AQUIND INTERCONNECTOR

Consultation Report – Appendix 1.7D Marine
Specific – Briefing Note of Meeting with MMO
18 July 2019

DATE: 14 NOVEMBER 2019

Briefing Note for Ongoing Consultation: Responses to Marine Management Organisation PEIR feedback

DRAWING No: EN020022-ES-3.5 Sheet 1	REV: 01
--	------------

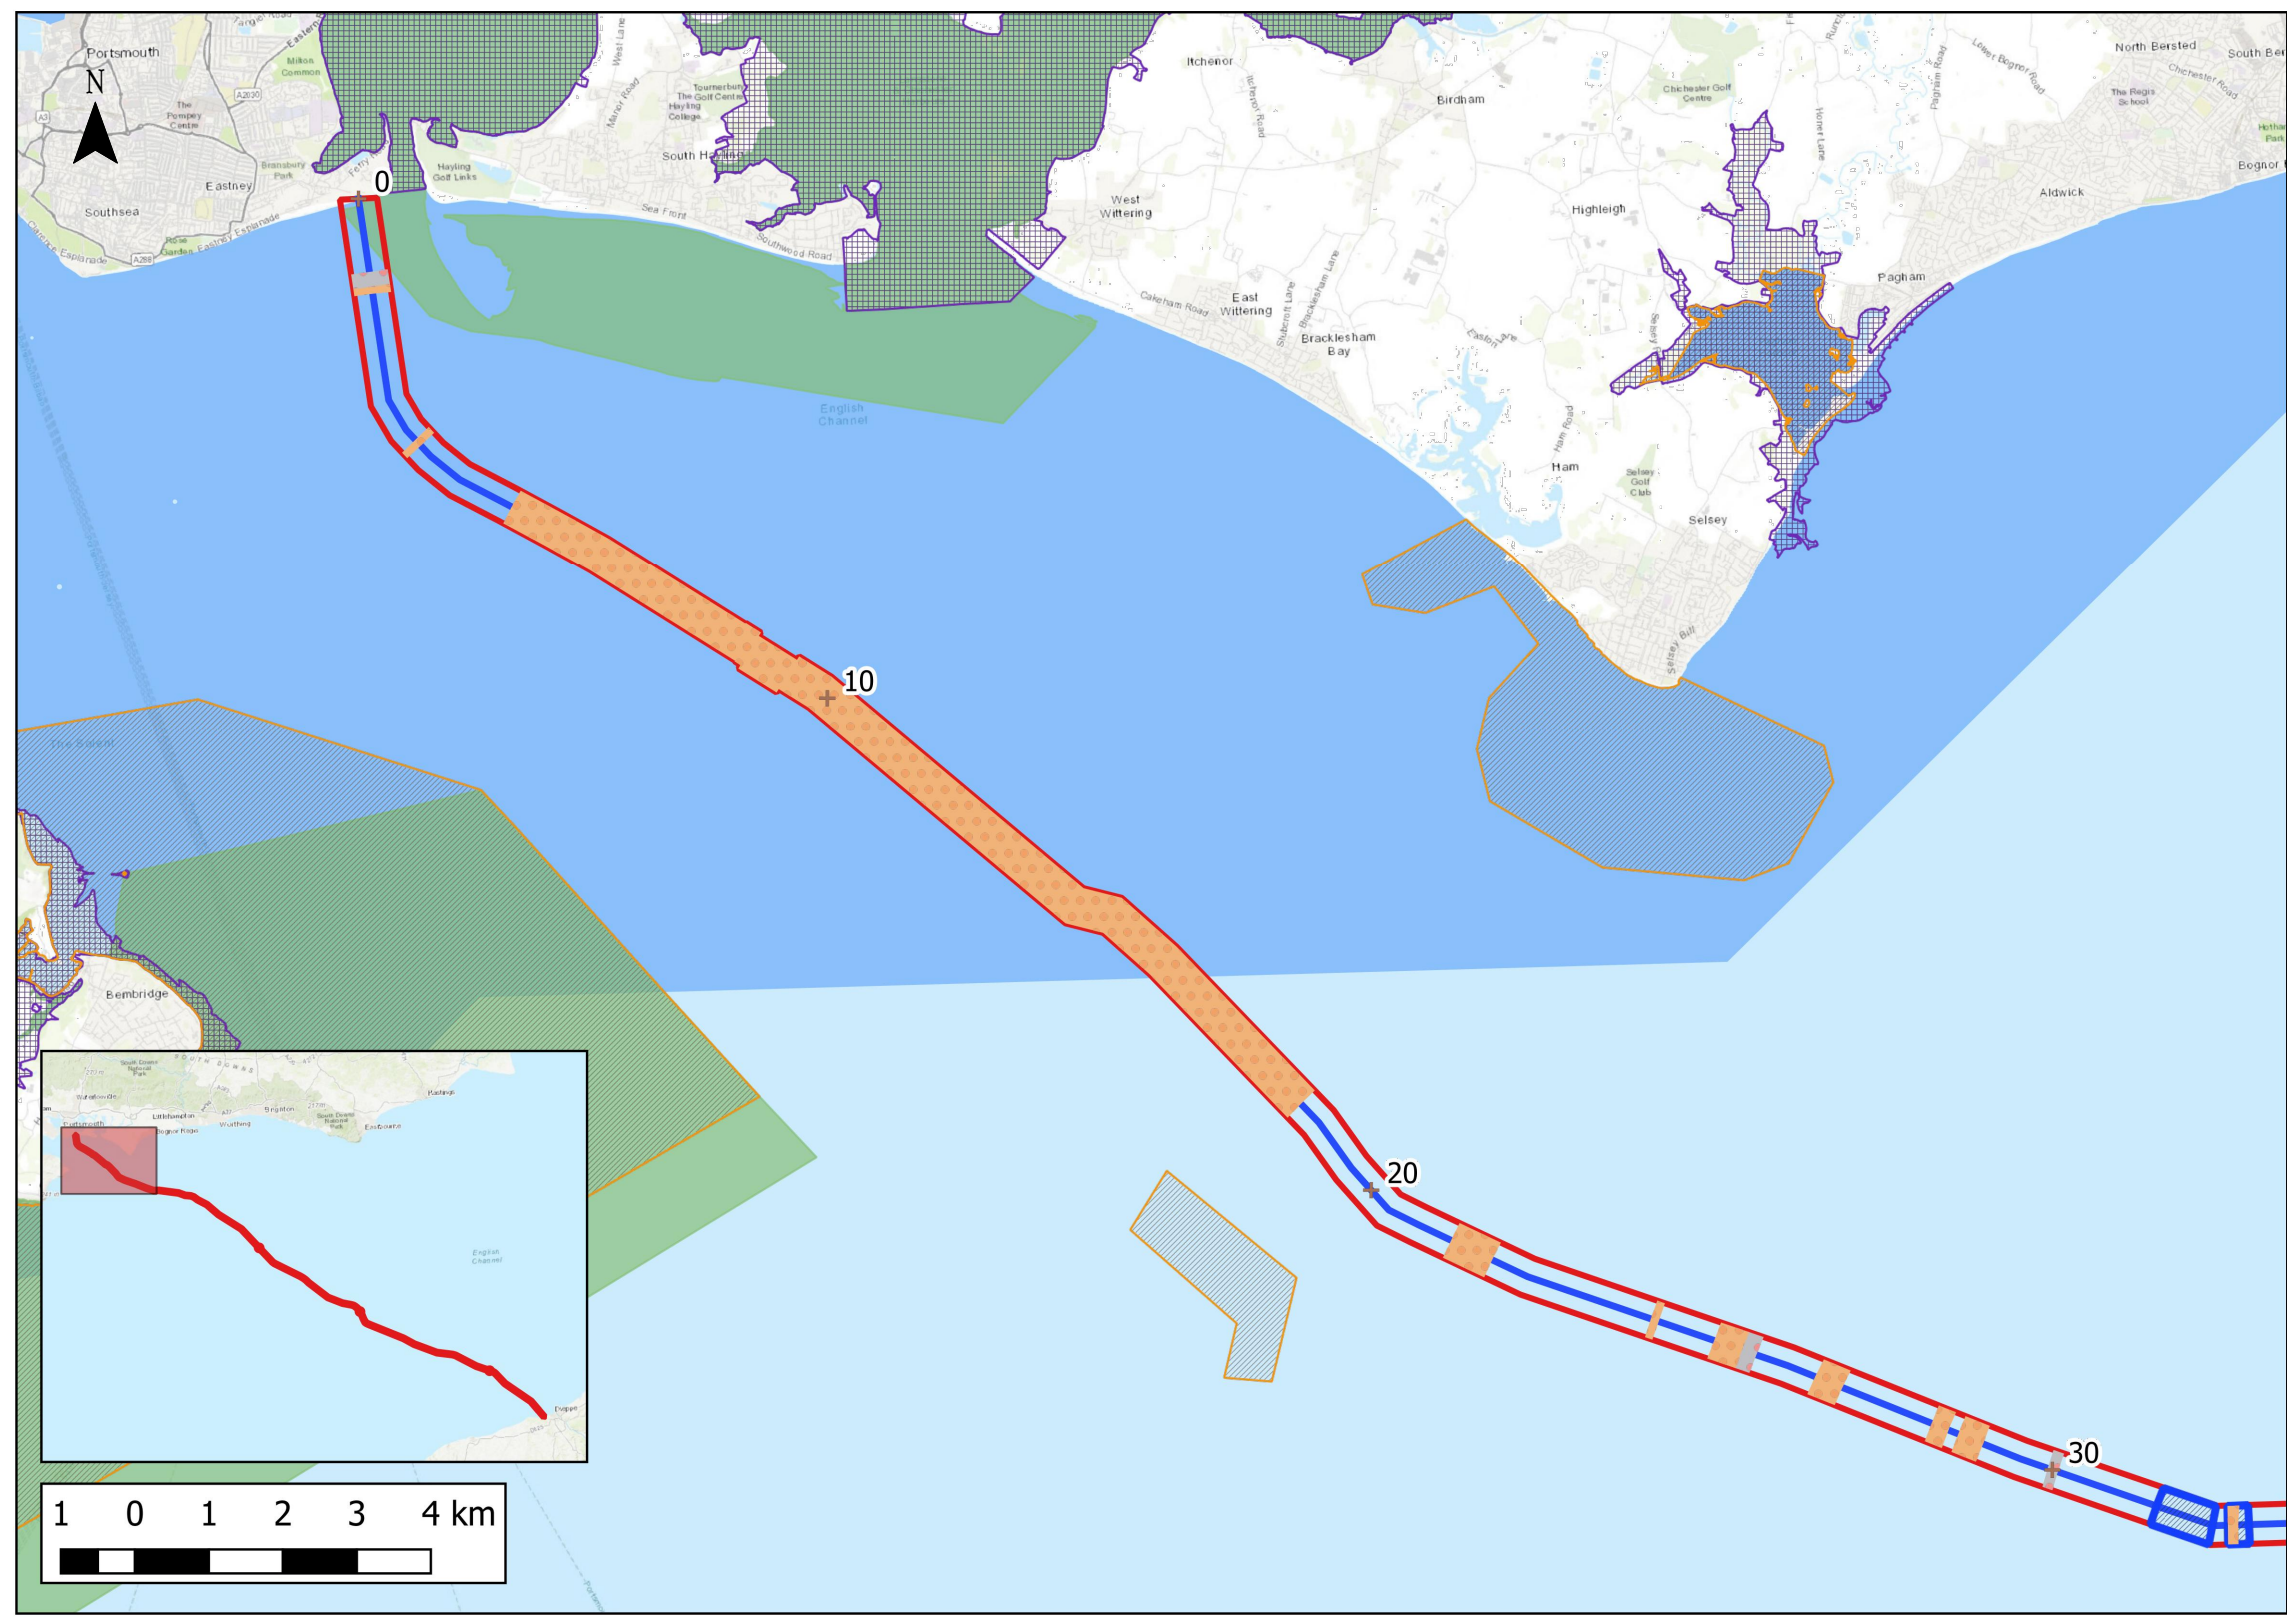
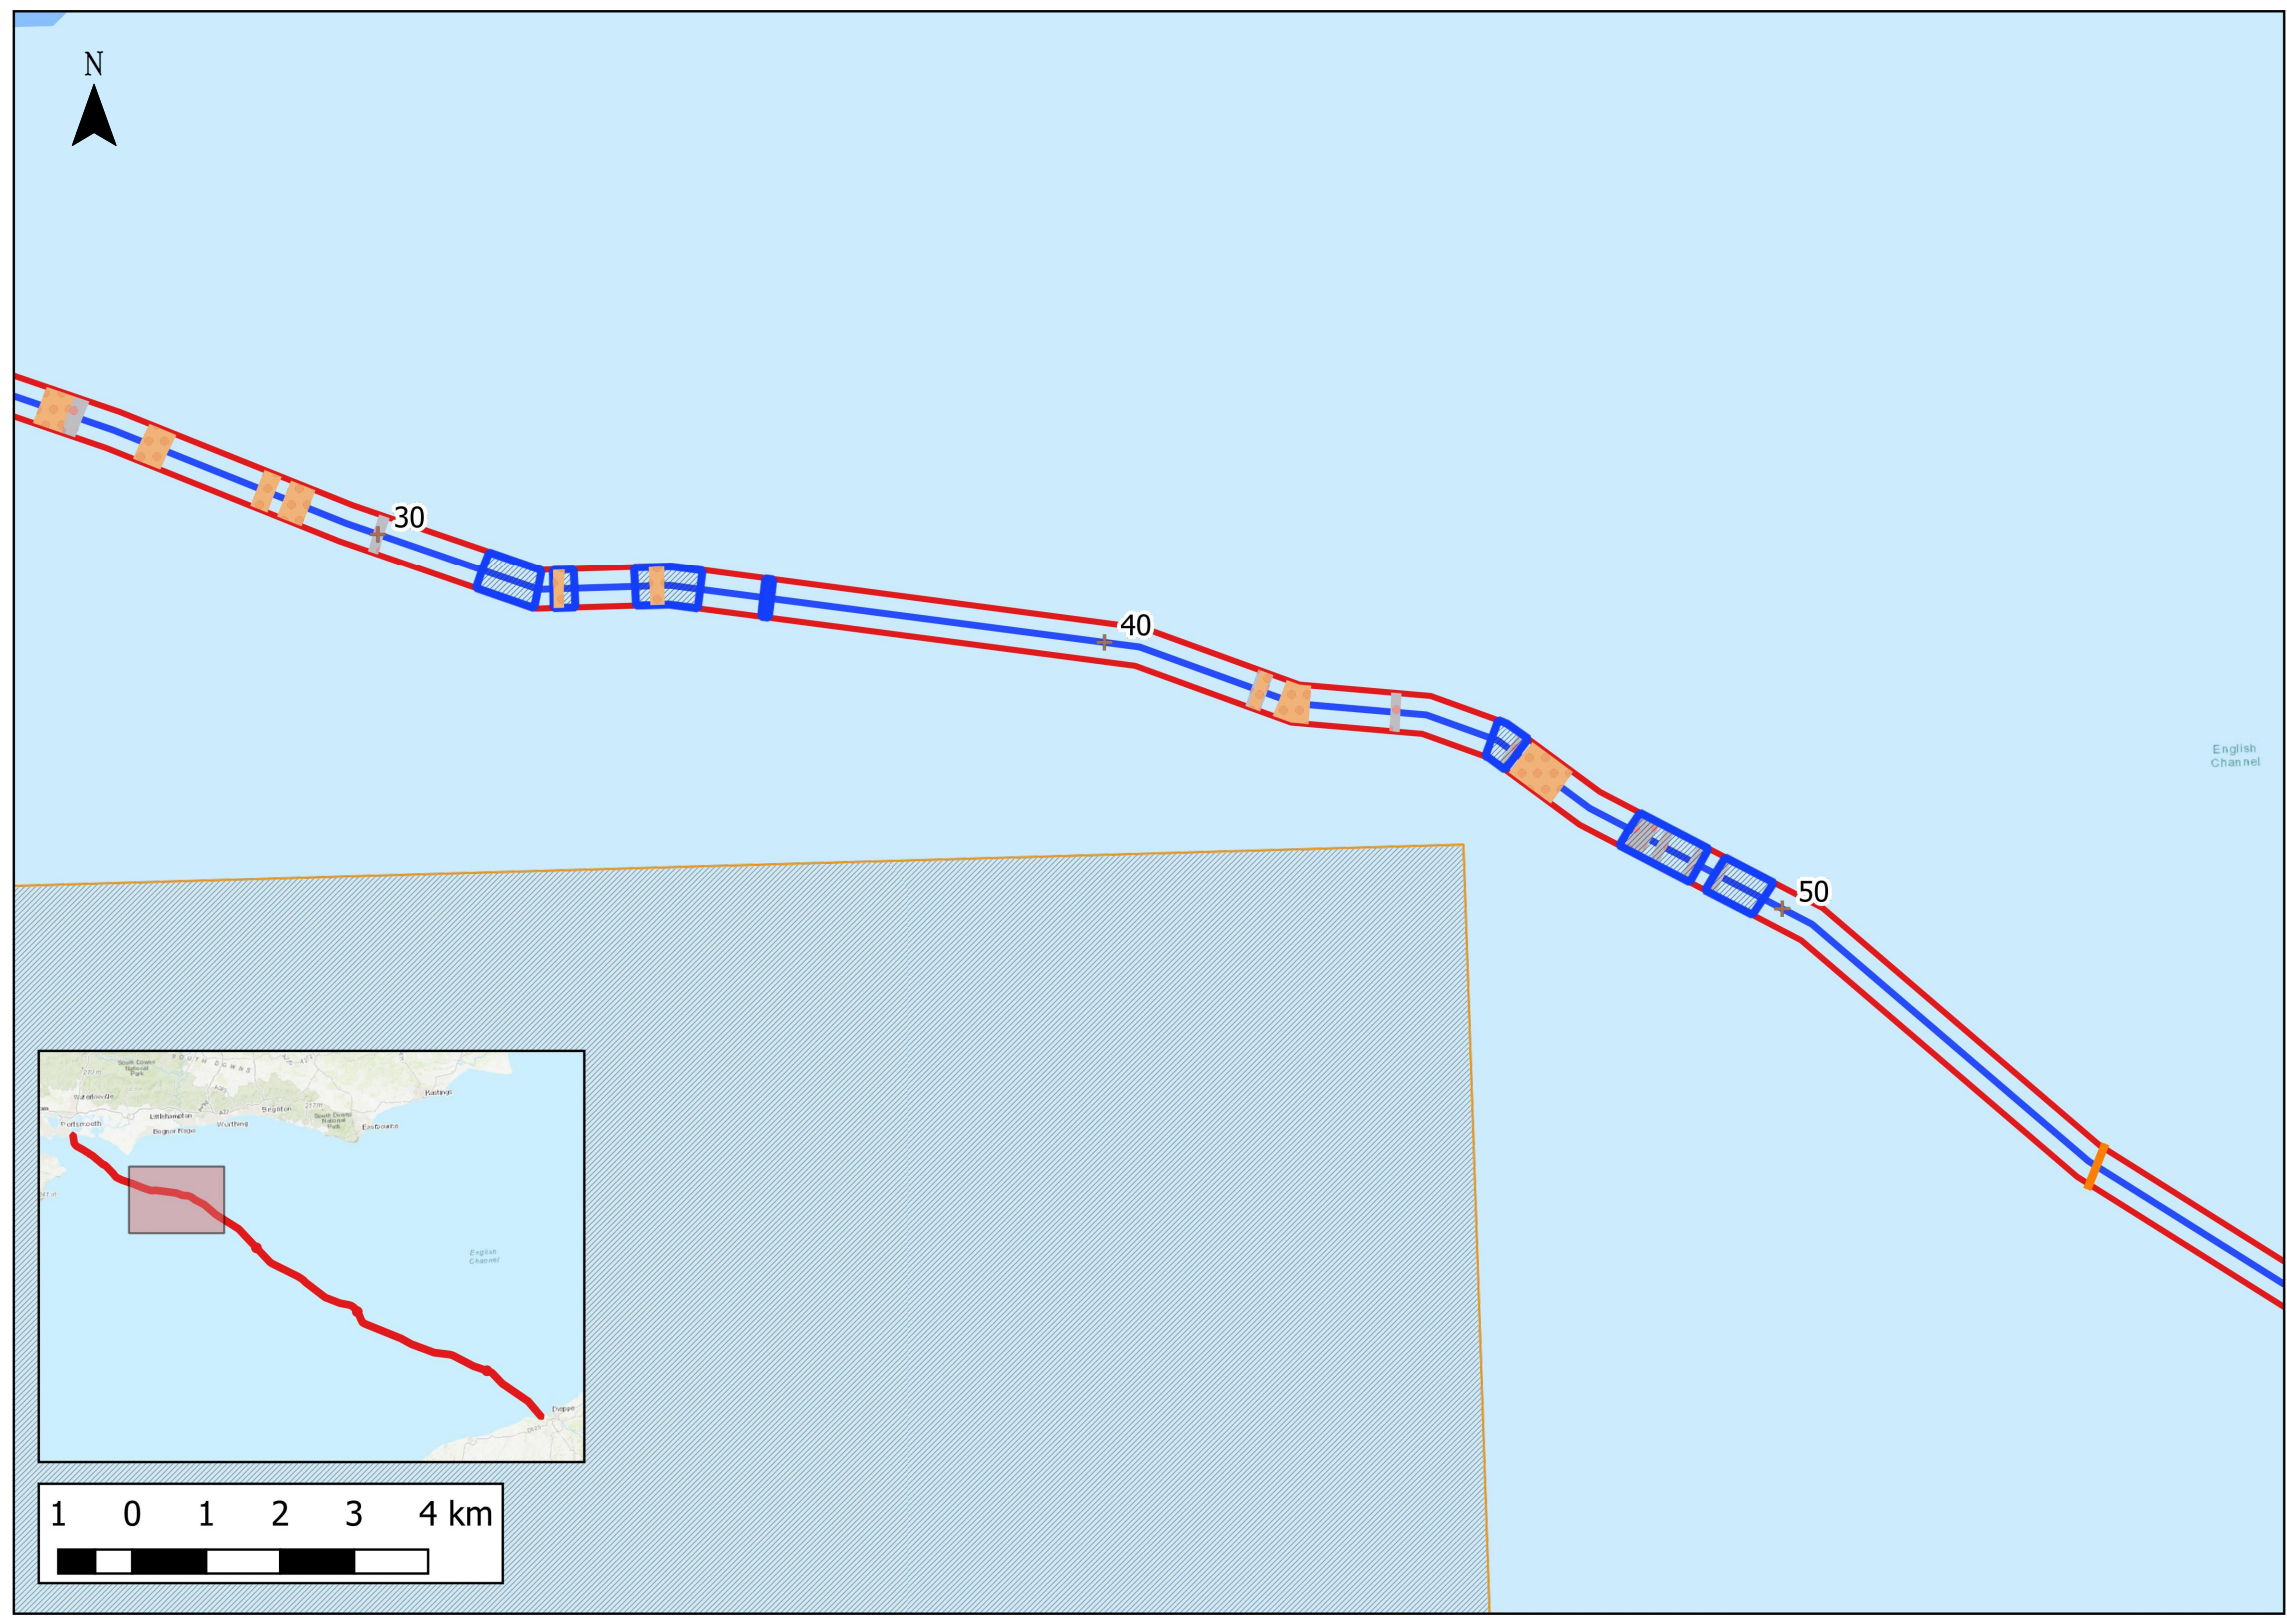
| Item | Topic | Comment | Applicant's Response | Teleconference Outcomes |
|------|--------------------|---|---|---|
| 5 | Physical Processes | Table 6.1 in the PEIR provides an overview of each comment from the scoping opinion, summarising how it has been addressed and clearly identifying the relevant section of the PEIR where this is done. Key comments in the scoping included: · A request to include tidal data for model validation, which has been undertaken (described in section 6.5). · A request to consider seabed features as receptors, which has been acknowledged in the PEIR and the applicant states that this will be accounted for in the ES. · A request for further detail on specific EIA approach and cross-referencing to other ES chapters to identify indirect linkages to other chapters has been (section 6.4 and chapter 4) · Details of embedded mitigation measures which were incorporated into project design have been described in section 6.7 and table 6.20. · More detail of non-burial cable protection was requested and further detail has been provided in chapter 3 and figure 3.5 | Acknowledged. | Cefas and the MMO have no further response. |
